CONSULTEE RESPONSE (Council's Arboriculturist)

Reference: AW/259/25/T

Location: 12 Margaret Close, Aldwick, PO21 3AA

Proposal: Crown reduction to 1no. English oak (T1) to leave a height of 15m, northerly spread of 5m, southerly spread of 3.5m, easterly spread of 6m, and westerly spread of 6m.

Tree Report

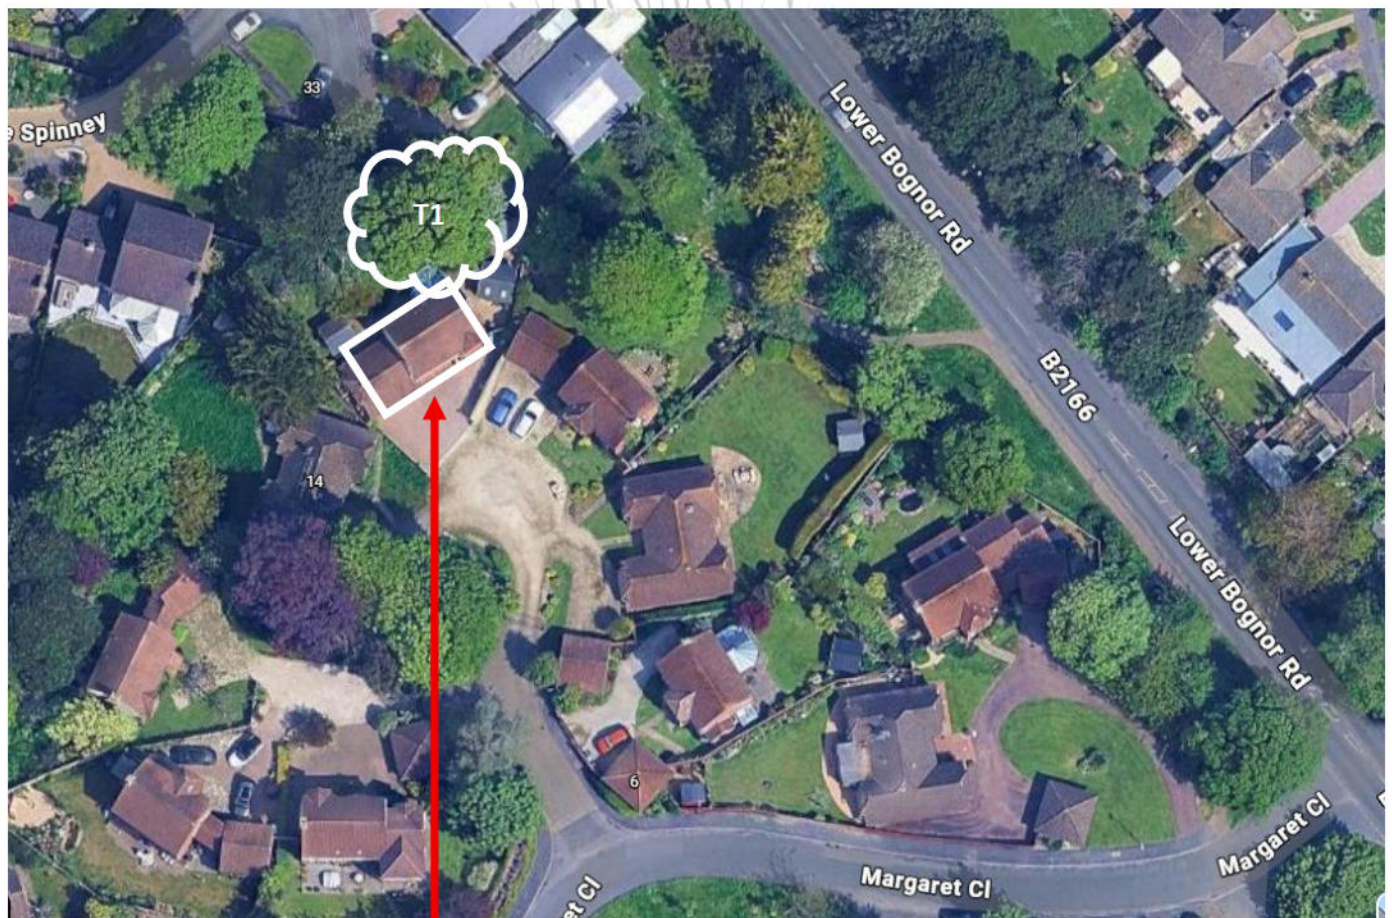
From roadside this tree appears to be in a fine physiological state and stable. It has a visually appealing crown profile, a result of limited pruning in the upper crown, which is visible from surrounding properties.

It should be assumed that the tree has high growth potential. Sadly constrained and partly obscured by proximity of dwellings, it nonetheless contributes to the high canopy which defines the character of the area.

It is proposed that only small diameter branches are reduced to leave a minimum of 3.5metres on the tree's southern side when measured from the bark of main stem. There will be no reduction of crown height or spread on any other aspect.

Whilst I find the reasons for the proposal insufficient to justify the work on arboricultural grounds, it is foreseeable that future crown spread to the south will become problematic and so a degree of early intervention pruning to limit that effect is reasonable.

We grant consent for this application subject to the following condition:

Part a) Where whole branches are to be removed and final cuts made close to the trunk or branch union they are to be made as shown in Figure 2 of BS3998:2010

Part b) Where branches are to be shortened back the final cuts are to be made at the correct angle shown in BS3998:2010 and adjacent to a live bud or lateral.
